**From:** De-Ruyck, Chris <Chris.De-Ruyck@e-lindsey.gov.uk>  
**Sent:** 08 January 2025 14:38  
**To:** Sutton, Catherine  
**Cc:** \_planningadvice  
**Subject:** H17-0983-24 : 80 Seas End Road, Surfleet

I have reviewed the BNG assessment and statutory metric file for the above application and judge them to be suitably rigorous and sound. I also support the bat, bird, and bee provisions recommended in the report. However, there is one issue that requires addressing before we can be confident that the proposed development will meet the mandatory 10% biodiversity net gain requirement.

Scale	1:200 @ A1	Drawing No.	2403-02-B
Date	JULY '24	Drawn	JC

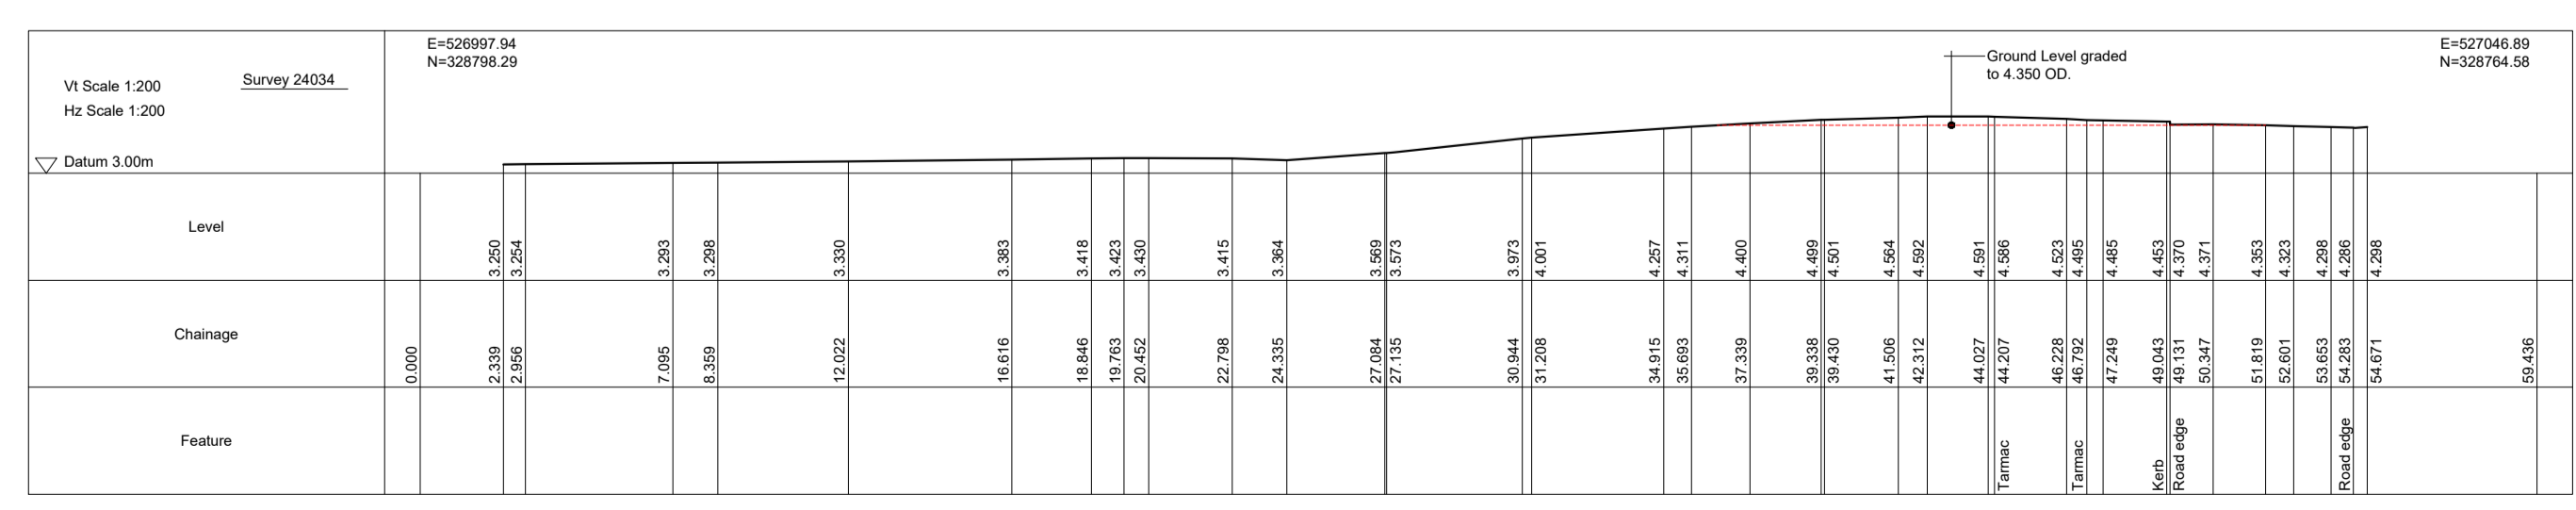
There is an error in the post-development statutory metric information in that all new planted trees must be recorded in the “small” size category for the tree-area calculations unless they are larger than 30 cm diameter when planted. This is articulated on page 56 of the Statutory Metric Guide: “record newly planted individual trees as ‘small’, unless ‘medium’ size or above at the time of site-planting”. Thus, planting an extra heavy standard tree as proposed in the BNG report (diameter at breast height = 14-16 cm) still counts as a small tree as it is less than 30 cm (medium tree size class is 30cm – 75cm).

The downshot is that when making this correction in the metric, the percent increase in biodiversity units is reduced to < 1%. However, one simple approach to rectifying this issue is to plant 4 new trees in the biodiversity creation area, rather than just the single tree. This would have the effect of bringing the post-development biodiversity values back to ~ 14% net gain.

Once the metric calculations and landscaping plan are amended to address the tree-issue, I believe the authority can have confidence that this development can achieve the mandatory 10% biodiversity net gain requirement. Note, that due to the extent of habitat creation/enhancement on-site, we will require the applicants to submit a habitat management and monitoring plan (HMMP) along with the biodiversity gain plan to discharge the biodiversity gain condition pre-commencement. I would refer the applicants to the small-sites HMMP template and HMMPT checklist available from: [Habitat Management and Monitoring Plan Template - JP058](#).
